**KIRKLEES METROPOLITAN COUNCIL  
INVESTMENT & REGENERATION SERVICE**

**DELEGATED DECISION TO DETERMINE PLANNING APPLICATIONS**

Reference No:	<b>2025/62/90469/E</b>
Site Address:	3, Park Mews, Farnley Tyas, Huddersfield, HD4 6BX
Description:	Erection of first floor side extension over existing garage and alterations to part convert garage to living accommodation (within a Conservation Area)
Recommending Officer:	Jennifer Booth

**DECISION - REFUSED**

Proposed First Floor Layout  
Scale 1:50

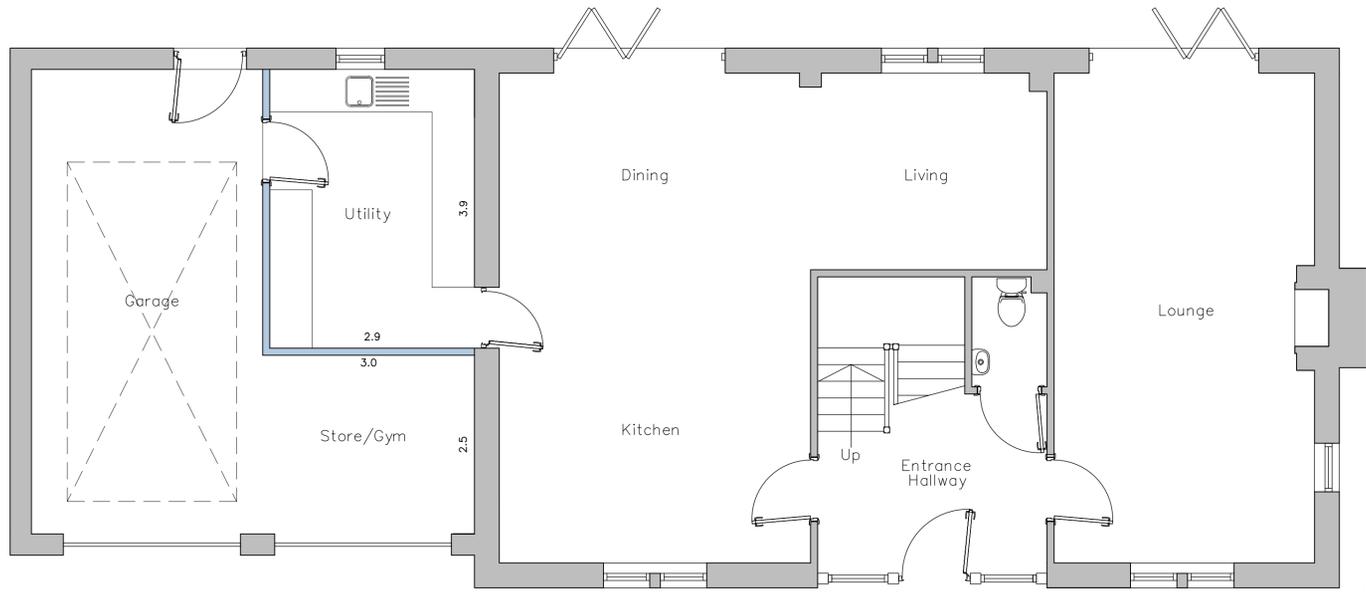
The proposals include a set back and a set down. Although it is noted that there would be no gap to the side, the stepped nature of the properties is such that there would be no terracing impact and the sense of space between the properties would be retained. The materials proposed would match the main house and the detailing is considered to be appropriate. The first floor side extension and the partial garage conversion, which includes no external alterations, are considered to be acceptable in terms of visual amenity.

The proposals will result in some intensification of the domestic use and the loss of one space within the garage. However, one of the garages would be retained and the parking area to the front of the property would not be affected by the proposed extension and is considered to represent a sufficient provision. Bin storage for the dwelling would not be moved as part of the proposals. As such the scheme would not represent any additional harm in terms of highway safety and as such complies with Policy LP22 of the Kirklees Local Plan along with Key Design Principles 15 & 16 of the House Extensions & Alterations SPD.

Proposed West Facing Side Elevation  
Scale 1:100

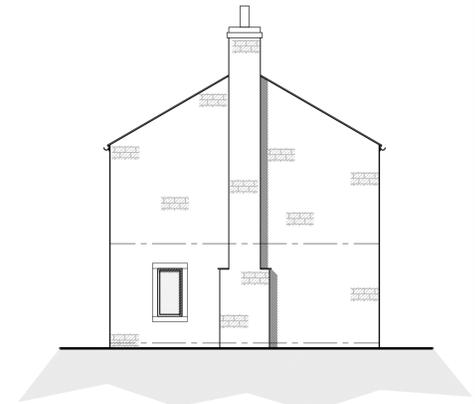
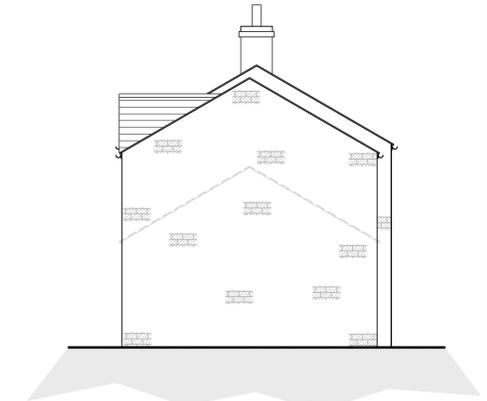
It is noted that the garage is situated on the boundary with the adjacent property and this already has some impact on the amenity space of the adjacent dwelling. However, by increasing the height, the extension would have an overbearing and oppressive impact on the first floor windows of the adjacent dwelling. The windows proposed would look over the applicants amenity space with limited potential to overlooking the adjacent dwelling.

Having considered the above factors, the proposals are considered to result in an adverse impact upon the residential amenity of the occupants of the adjacent 2 Parks Mews with regards to overbearing and oppressive impact, thereby failing to comply with Policy LP24 of the Kirklees Local Plan (b) in terms of the amenities of neighbouring properties, Key Design Principles 3, 5, 6 & 7 of the House Extensions & Alterations SPD and Paragraph 135 (f) of the National Planning Policy Framework.

1. The first floor side extension due to its scale and positioning, would result in an overbearing and oppressive impact on the first floor windows of the adjacent 2 Park Mews reducing light and outlook to the accommodation to the detriment of the occupants. To permit the proposals would be contrary to Policy LP24 of the Kirklees Local Plan, KDP5 of the House Extensions & Alterations SPD and Chapter 12 of the National Planning Policy Framework.
